Your Ref: 2017/91677
Our Ref: T008749

20th June 2017

Land at Serpentine Road, Cleckheaton - Erection of 42 retirement living apartments, 83 bed care home with provision of communal facilities, landscaping and car parking and erection of 7 affordable dwellings

Drawn	MN	Chkd	AD	Date	February 2017	Scale	As shown @ A1
TE Reference.	16353-C-50		Drig No.	NE- 2106-03-DE-001		Revision	A

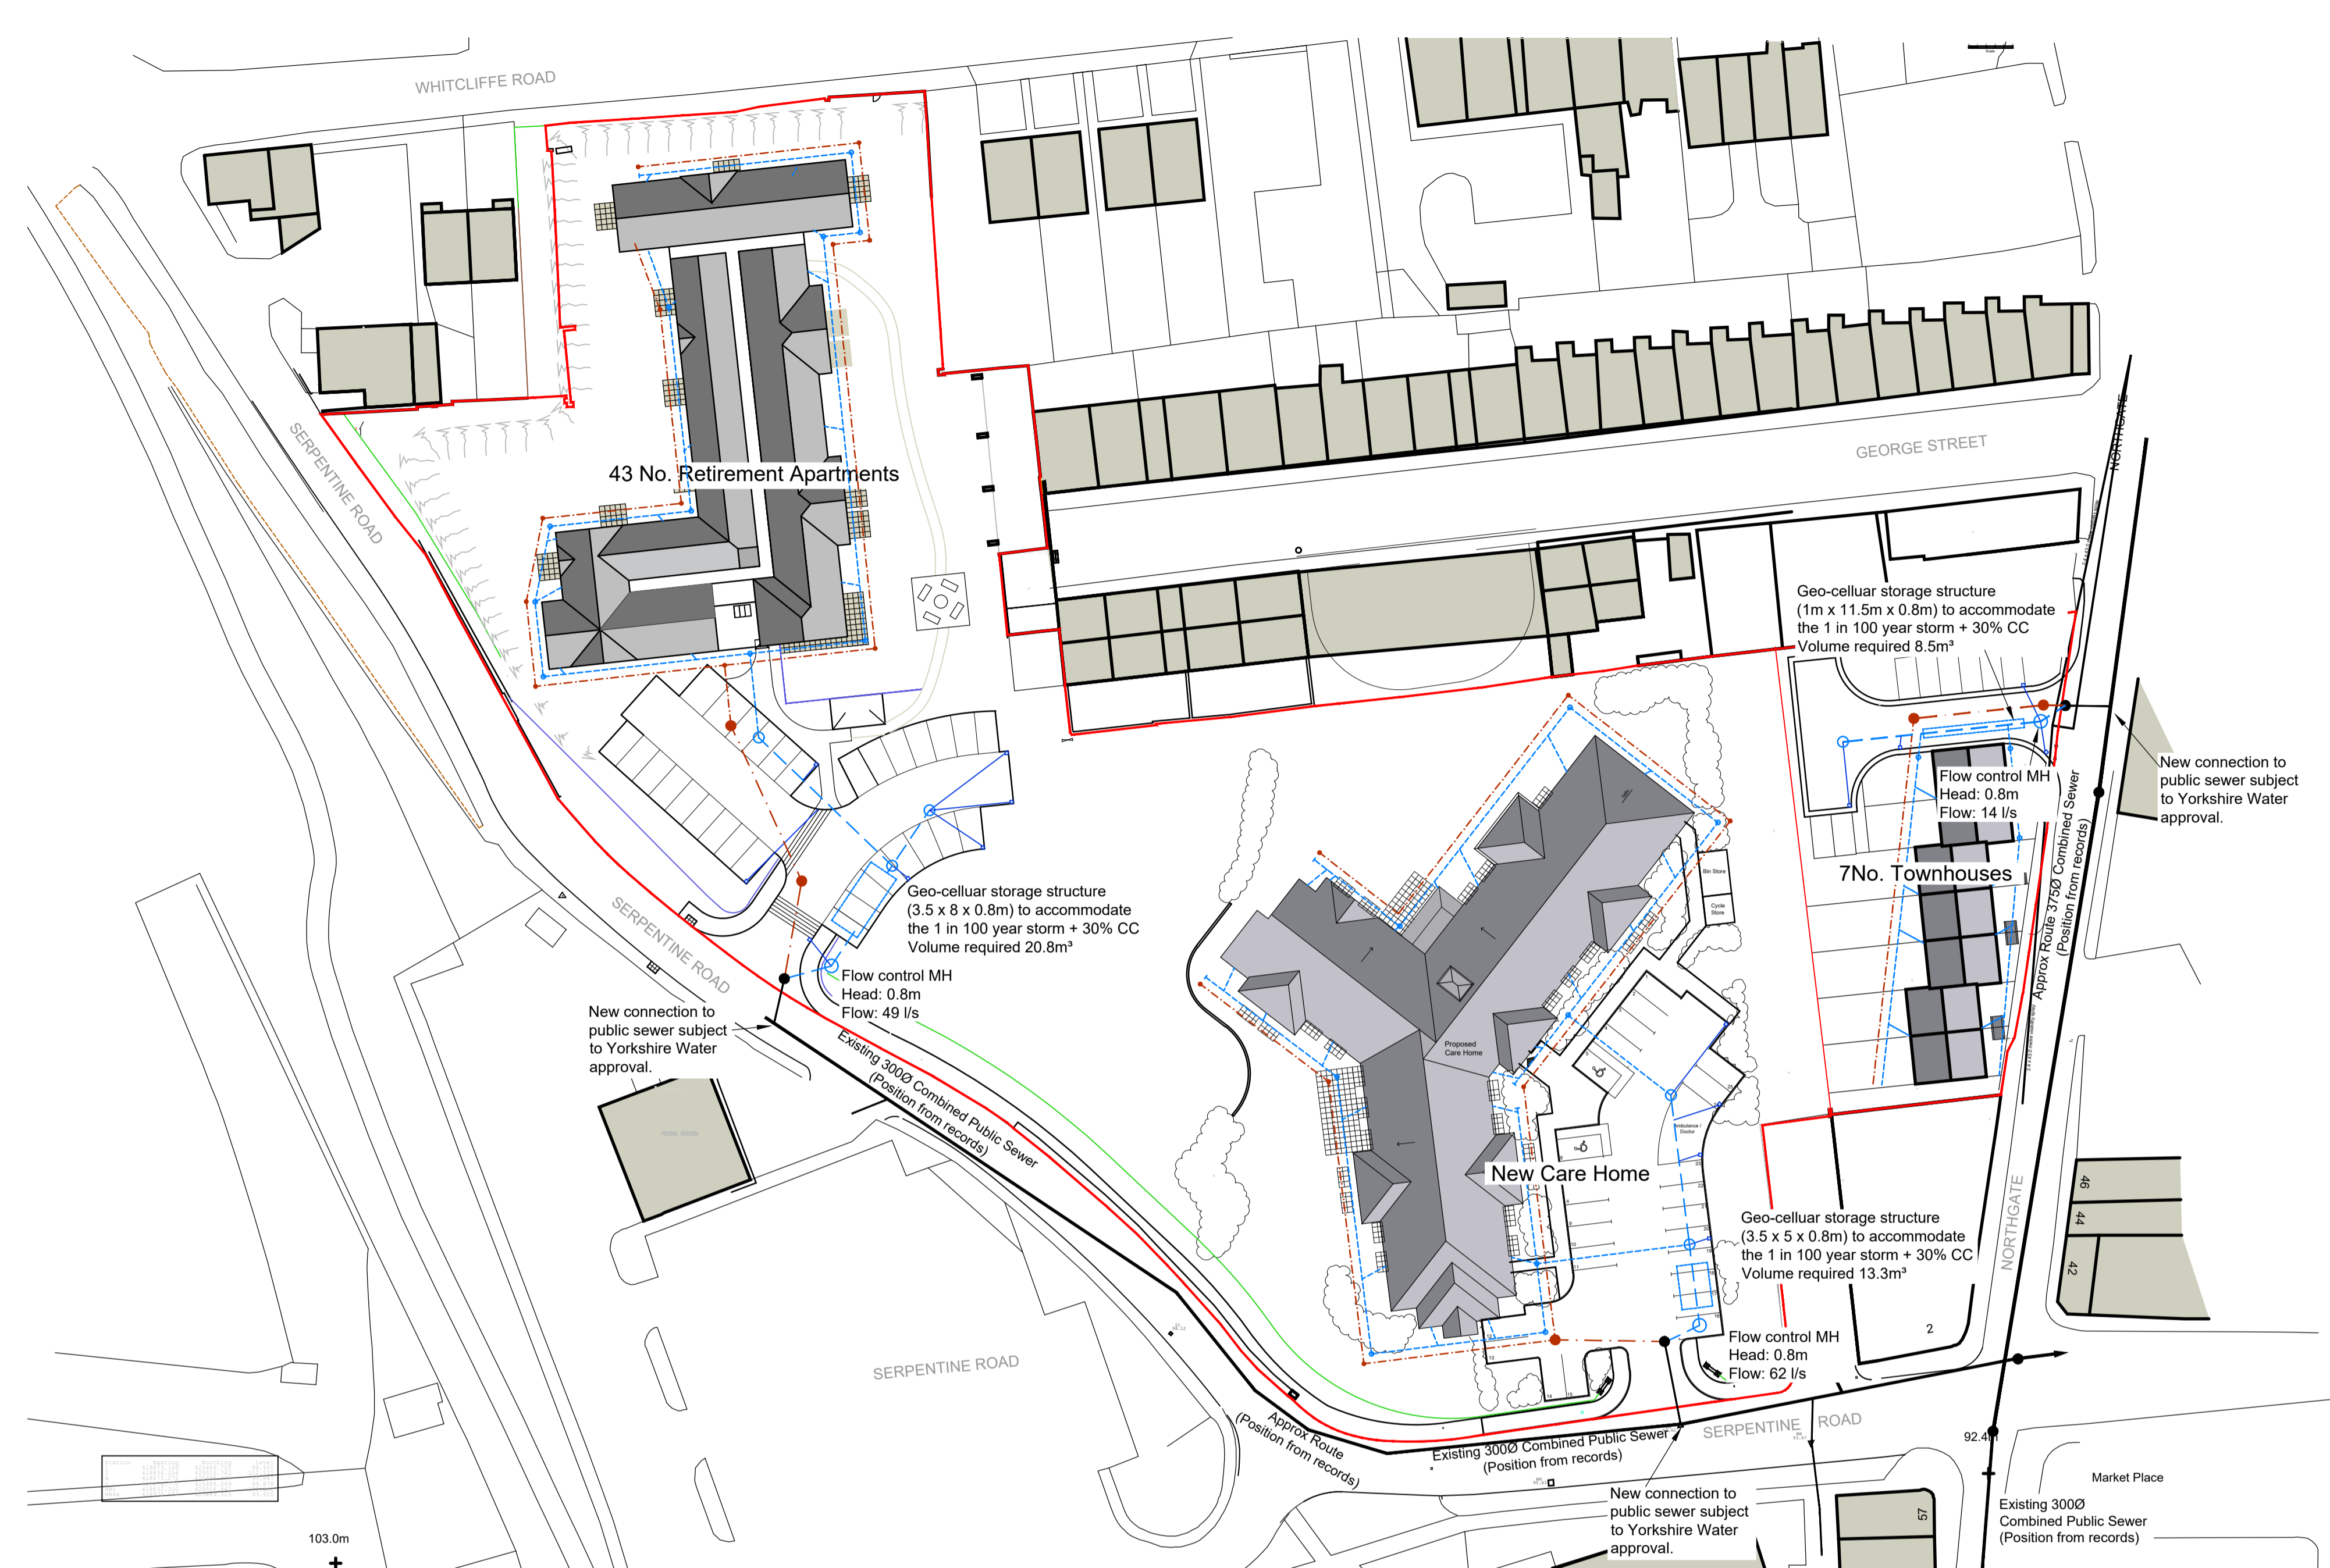
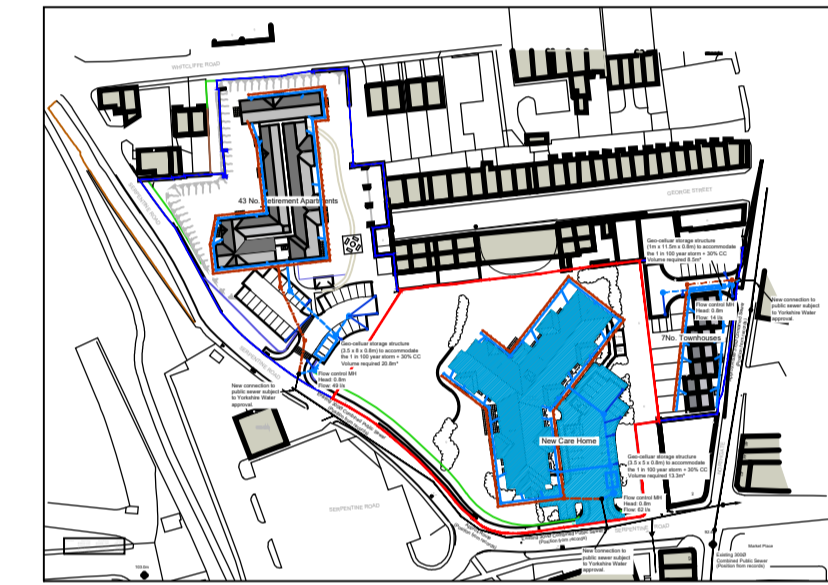
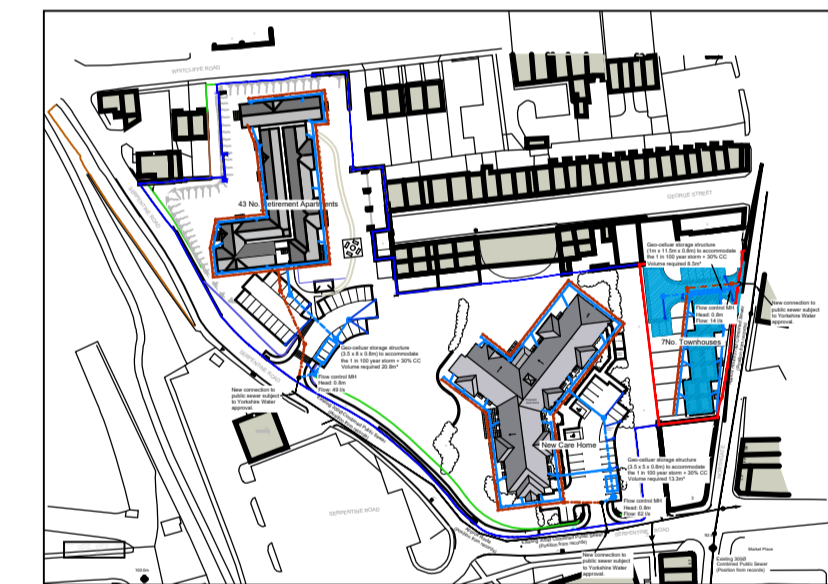
No development shall take place until details of the proposed means of disposal of surface water drainage, including but not exclusive to :-

**a) evidence to demonstrate that surface water disposal via infiltration or watercourse are not reasonably practical;
b) evidence of existing positive drainage to public sewer and the current points of connection; and**

**c) the means of restricting the discharge to public sewer to the existing rate less a minimum 30% reduction, based on the existing peak discharge rate during a 1 in 1 year storm event, to allow for climate change have been submitted to and approved by the Local Planning Authority .
Furthermore, unless otherwise approved in writing by the local planning authority, there shall be no piped discharge of surface water from the development prior to the completion of the approved surface water drainage works .**

- 1) Yorkshire Water has no comment to make on the Flood Risk Assessment (prepared by Topping Engineers - Report NE-2106-03-DE-FRA revision A dated April 2017) as the report does not detail a surface water strategy.

- 2) The Phase 2 Ground Investigation (prepared by Arc Engineering - Report 16-075 dated 31/03/2016) states that sub-soil conditions do not support the use of soakaways and so the developer is proposing to discharge surface water to public sewer. Surface water discharges to the public sewer must have a minimum of 30% reduction based on the existing peak discharge rate during a 1 in 1 year storm event. The developer will be required to provide evidence of existing positive drainage to a public sewer from the site to the satisfaction of YWS/the LPA by means of physical investigation. On-site attenuation, taking into account climate change, will be required before any discharge to the public sewer network is permitted.
